## Attachment A – Response to Submissions Table

**Table 1 Response to Submissions**

**2** HOTEL/SERVICED APARTMENTS L22  
1:200

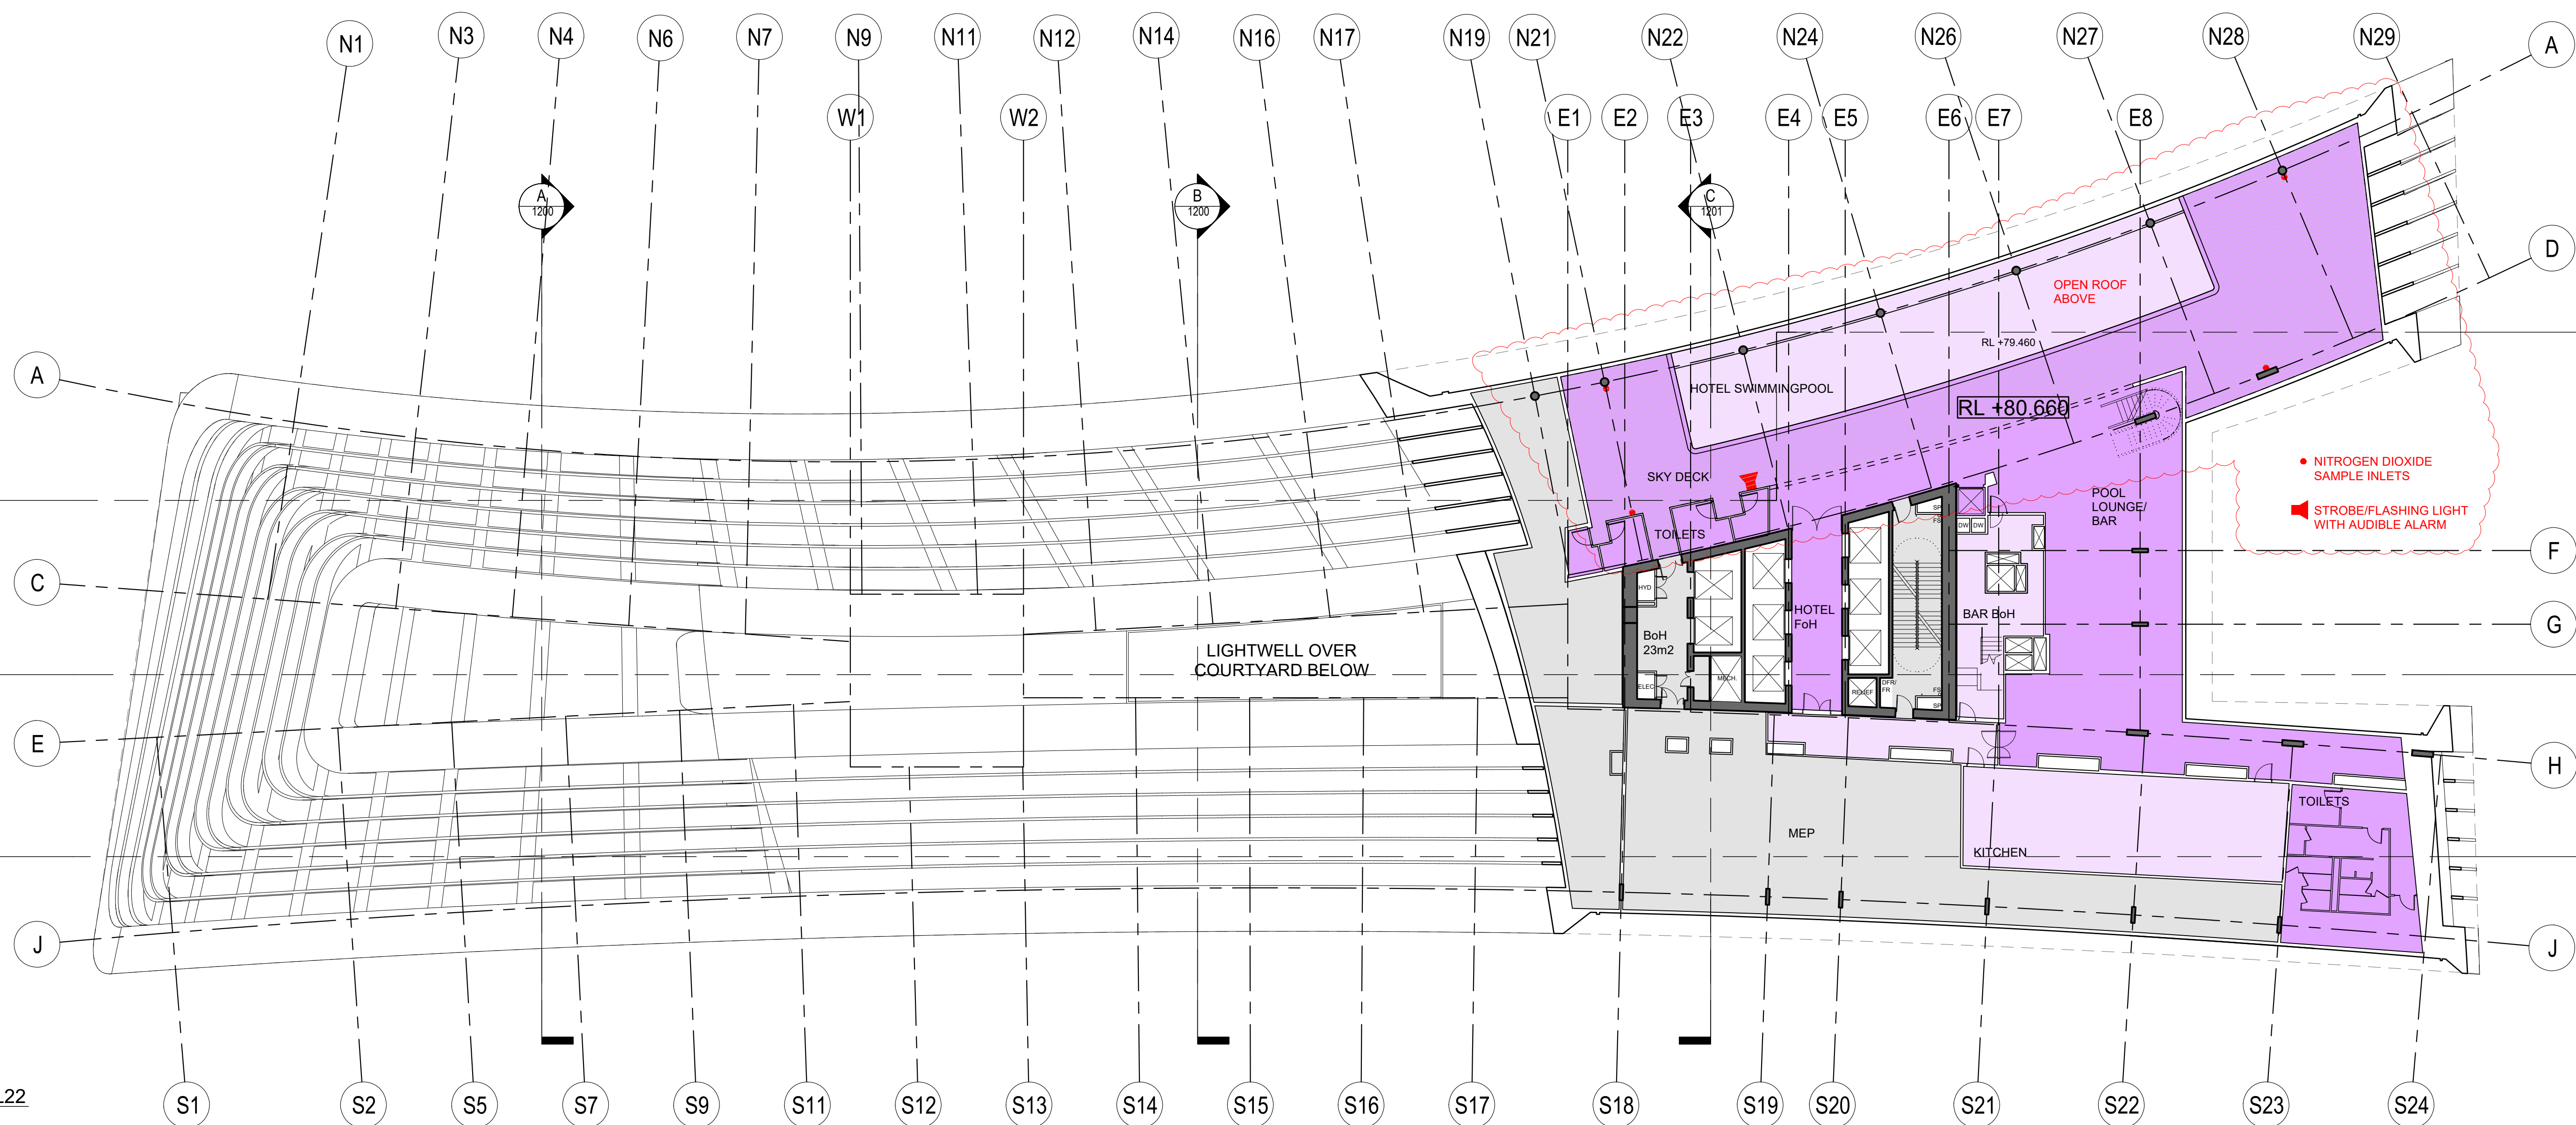
Issue	Response
<p><b>Plans</b>                      Clarify the rationale for the proposed number and location of NO<sub>2</sub> sensors. If the sensors are to be located externally, provide appropriately scaled drawings (including elevations) clearly illustrating the proposed sensors, mounting brackets and any weatherproofing or other housing proposed. Consideration should be given to minimising the impact to the external appearance of the building.</p>	<p>The updated architectural drawings provided at <b>Attachment A</b> illustrate that each of the four nitrogen oxide sensor tubes and analysers are strategically located internally near the ceiling perimeter of the open roof. A section demonstrating the location of the sensors has been provided below.</p>  <p>The elevated location of the sensors within the rooftop pool bar will minimise potential interference, whilst ensuring that air quality is reliably measured in the pool area.</p> <p>The proposed sensors will be small in size with a sensor diameter of 50mm that is protected and mounted by a stainless steel frame. Given this small size, the sensors will have a negligible impact on the overall visual appearance of the building, and will be largely invisible to the public eye. Elevations provided at <b>Attachment A</b> demonstrate the small scale of the proposed sensor units.</p>
